Application Ref: H09-1289-25

Proposal: **Proposed single storey rear extension and two storey side extension**

Location: **Tweenus, Cherry Tree Lane, Holbeach, PE12 7PX**

Requests that the Local Planning Authority request the applicants to provide additional information as set out below.

Client Name: Benjamin Traverso		E	Updated Block Plans	01.01.2026	
Drawing Title: Existing & Proposed Block Plan	Drawings No: PL - 25/100 - 19	Date: 01.01.2026				
	Drawn by: HK	Scale: As indicated

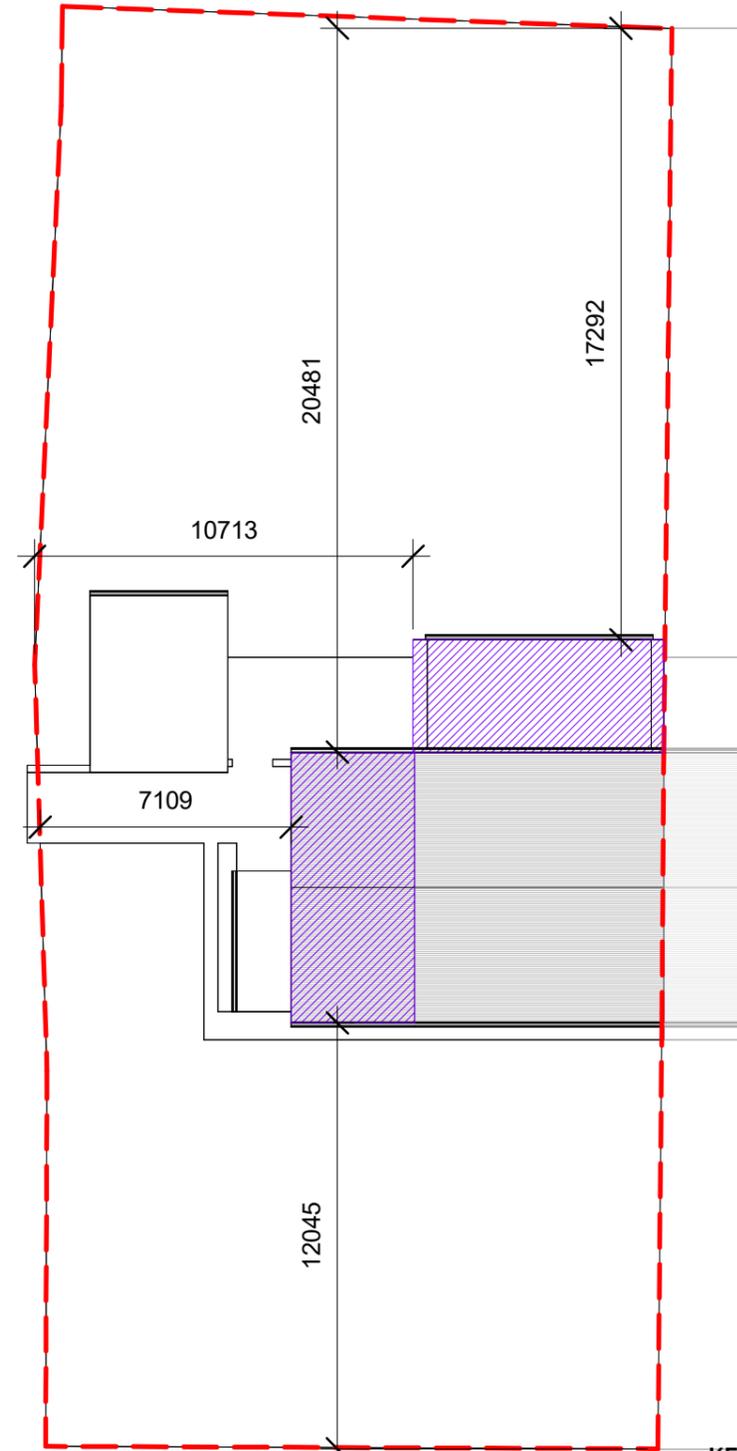
The proposal will increase the bedrooms from three to five so this will increase parking demand. For a five-bed house they should provide 4 parking spaces. This needs to be shown on the proposed site plan.

The access needs to be upgraded to Lincolnshire County Council Specification – a note is required on the proposed site plan.
